Subject: FP/246/21/PL - 26 Felpham Road Felpham PO22 7AZ

Planning Application Reference: FP/246/21/PL

Proposal: Change of Use from retail shop to cafe, including installation of new external kitchen extract duct and bifold doors. This application is in CIL Zone 4 (zero rated) as other development.

Location: 26 Felpham Road Felpham PO22 7AZ

SOUTH ELEVATION

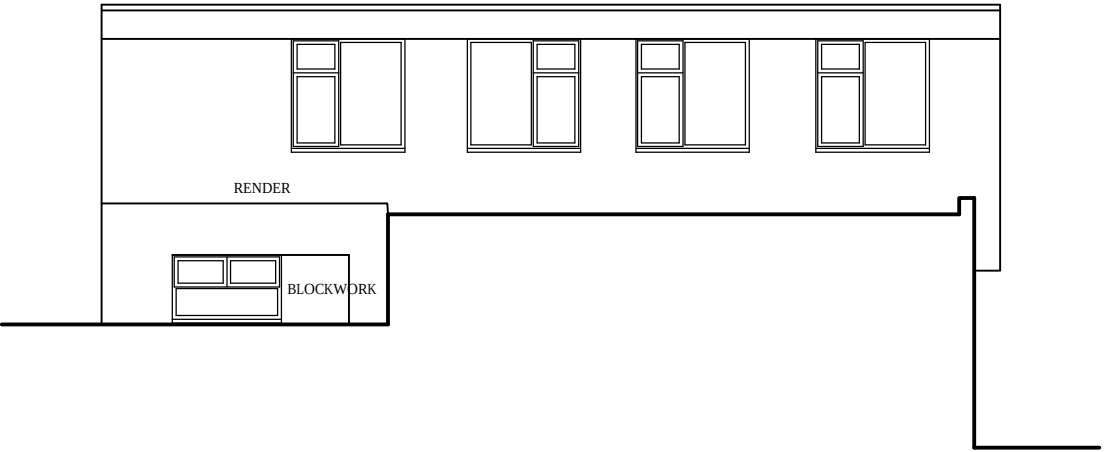
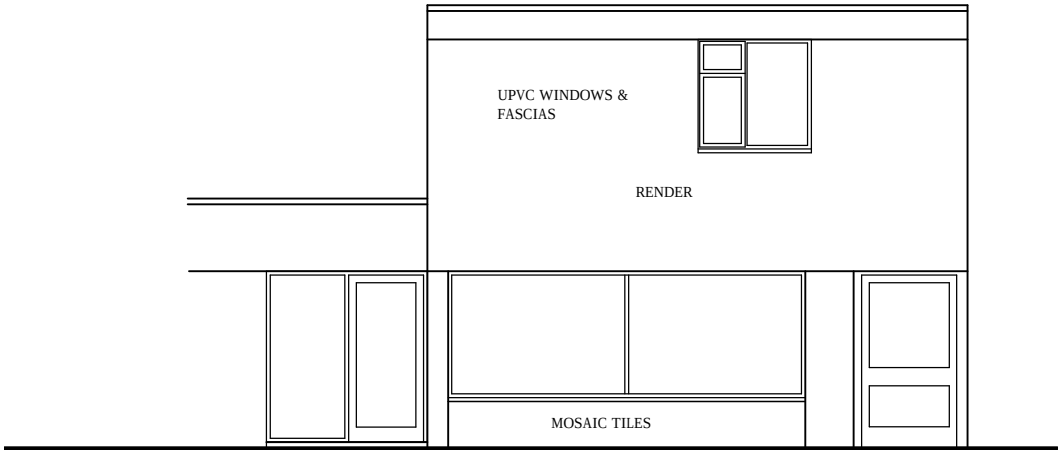
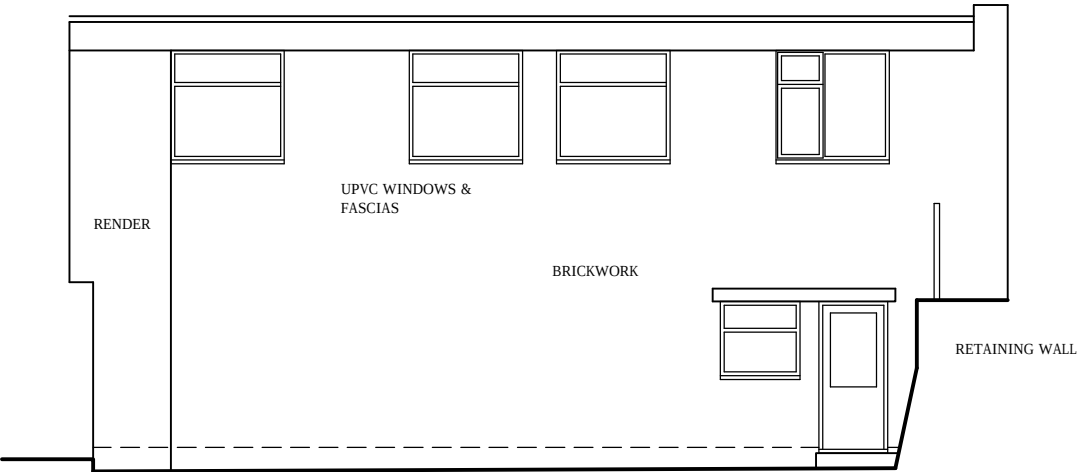
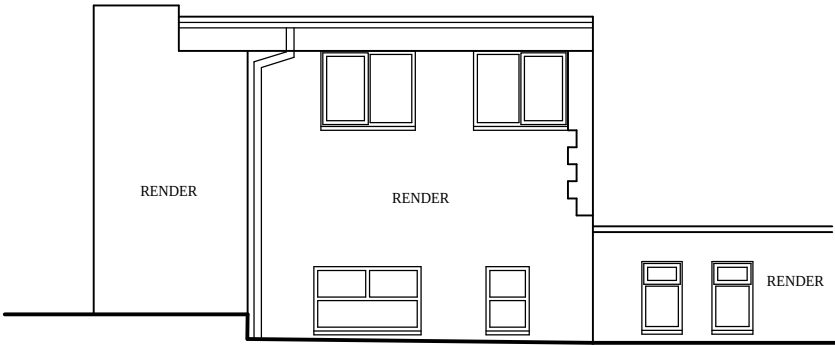
Having reviewed the documents entitled 'Design statement' and 'Vent/extraction statement' there appears to be no information to ascertain whether appropriate odour control is included with the proposed extraction system. Details of the noise impact from the proposed system on the nearest sensitive receptors are also minimal.

I also request the applicant provide information to identify the noise level at the façade of the nearest sensitive receptor. Where information has been provided regarding the sound level from the inlet and outlet fans, no calculation has been made to inform what the noise impact shall be on sensitive receptors. The Design statement mentions two sound attenuators, however there is no performance value included.

I therefore request the applicant be required to carry out a risk assessment in accordance with the criteria detailed in the EMAQ document 'Control of Odour and Noise from Commercial Kitchen Exhaust Systems, 2018' and provide details to demonstrate the proposed extraction system meets the odour control requirements resulting from the risk assessment.
